Winchester
City Council

Subject: Response to invitation to comment on matters raised at Preliminary Meeting held online on 18 August 2020

Application by AQUIND Limited for an Order Granting Development Consent for the Aquind Interconnector Project.

**Plate 2.9 - DC Cable Route Options (Feb 2017)**

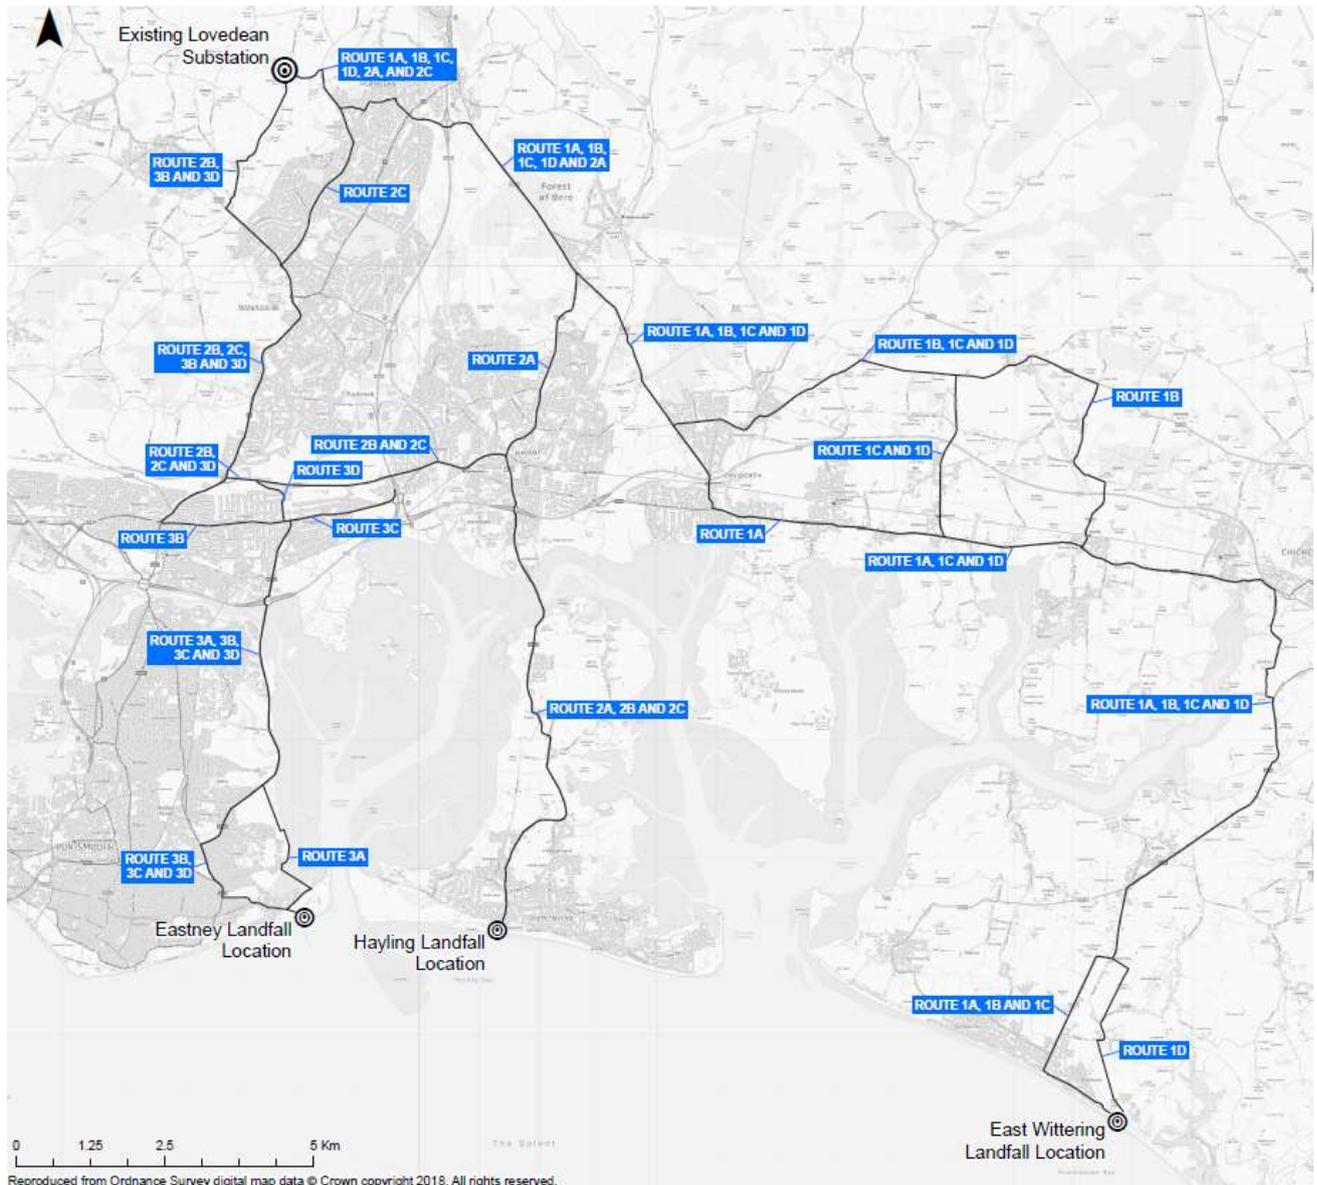
- East Wittering,
 - Hayling Island and
 - Eastney.
- 1.11 The routes from these landfall points to Lovedean are show on Plate 2.9 (DC Cable Route Options). They all show the cables being laid in the highway.

- 1.12 Section 2.4.11.5 does refer to consideration being given to shortening sections of the cable route by going off road across fields. In the assessment of the Eastney Portsea Island landfall to Lovedean option, no indication is given of the consideration of a cross country route west of the A3.

**Plate 2.10 - Cable Route 3D (blue) and Cable Route 1D (pink)**

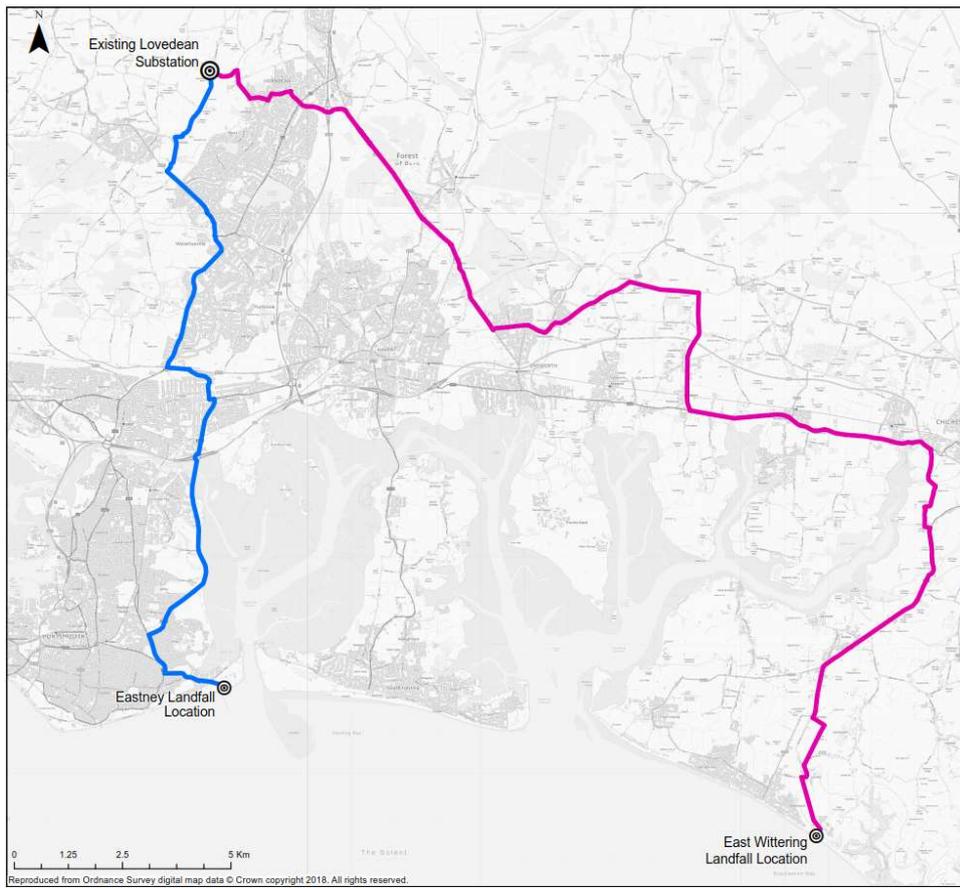
- 1.13 Section 2.4.13 (UK Cable Routes Detailed Desk Studies of Route 1D & 3D) June 2017 indicates that a further assessment of the Eastney to Lovedean cable route was made. The section makes no reference to the consideration of the cross country route being assessed against the road route.

**Plate 2.13 – Alternative Countryside Routes (as proposed by WCC and HBC)**

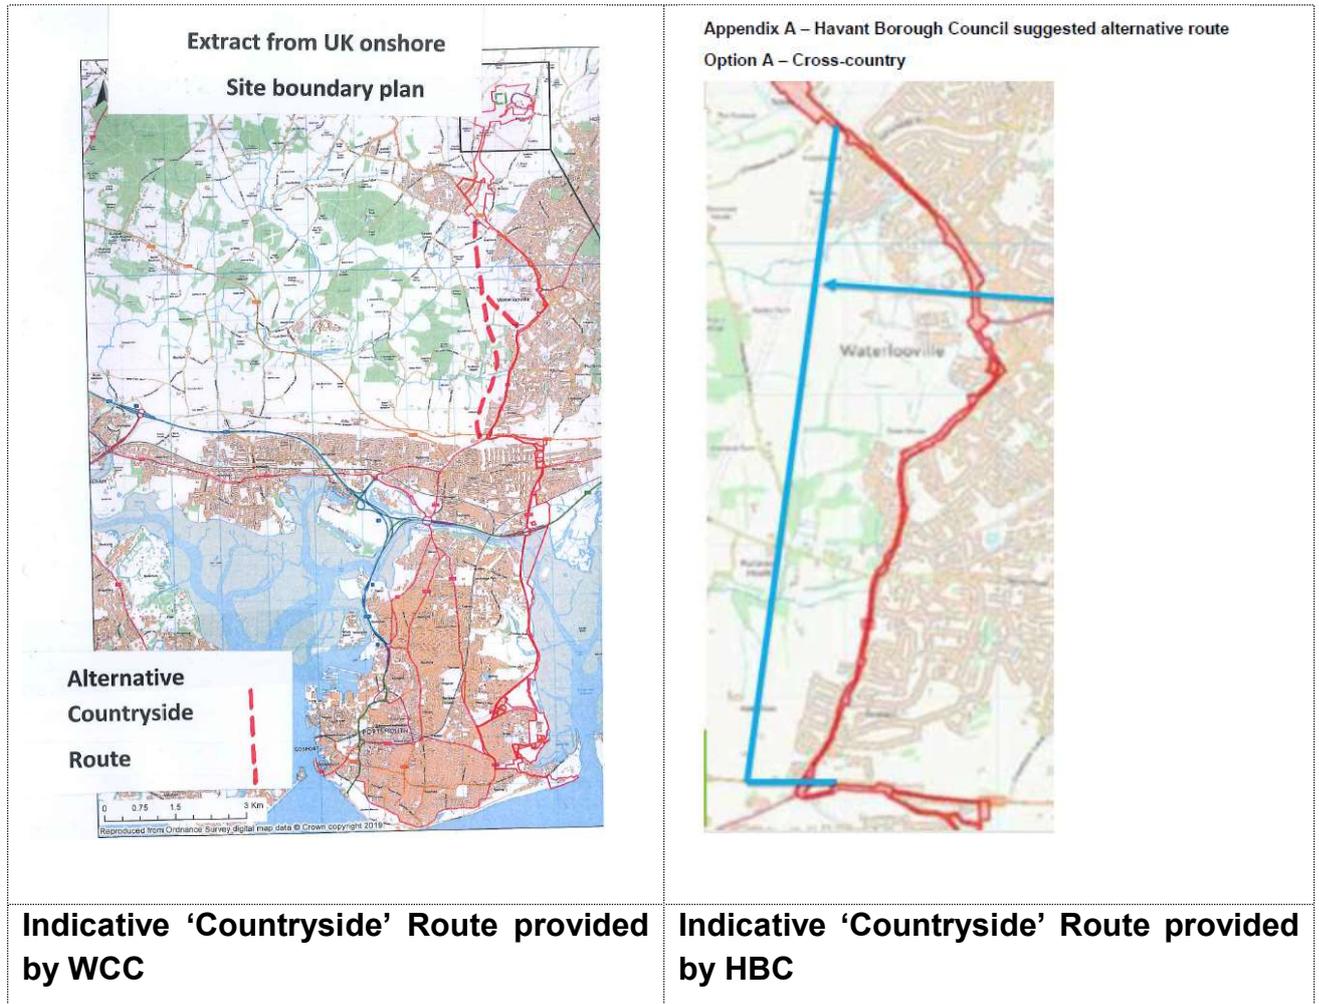
- 1.14 Section 2.6.4 outlines the response to the WCC and HBC Alternative Countryside Route which those authorities raised in their responses of April 2019 to the PEIR consultation exercise. Two comments are made in response to this section.

- 1.15 Firstly, this is the only point in the submission at which point the applicant addresses the Cross Country route. The optioneering process is silent about any consideration of the cross country route prior to this section. It seems likely that had the two councils not raised it in their responses to the PEIR then the Environmental Statement may well have been totally devoid of any reference to it.

- 1.16 Secondly, the table as presented in 2.6.4 is not a fair assessment of the two options one against the other. It is not an easy process considering the environmental impacts of a countryside route compared to that following an urban route. The countryside option will inevitably score higher on environmental impacts. What is lacking is a more detailed analysis beyond the simplistic observation that there will be some “temporary short term impact on traffic” (2.6.4.5) if the road route is followed. Just as the Environmental impacts are listed in the table so the socio economic impacts need identifying and weighing. These cover the potential delays to traffic including emergency vehicles and the potential to inhibit future work to maintain or enhance the road network or service future development through the presence of the cables in the road. The fact the applicant has not explored these in a greater level of detail and that the level of impact is still emerging is viewed as a deficiency in the process.
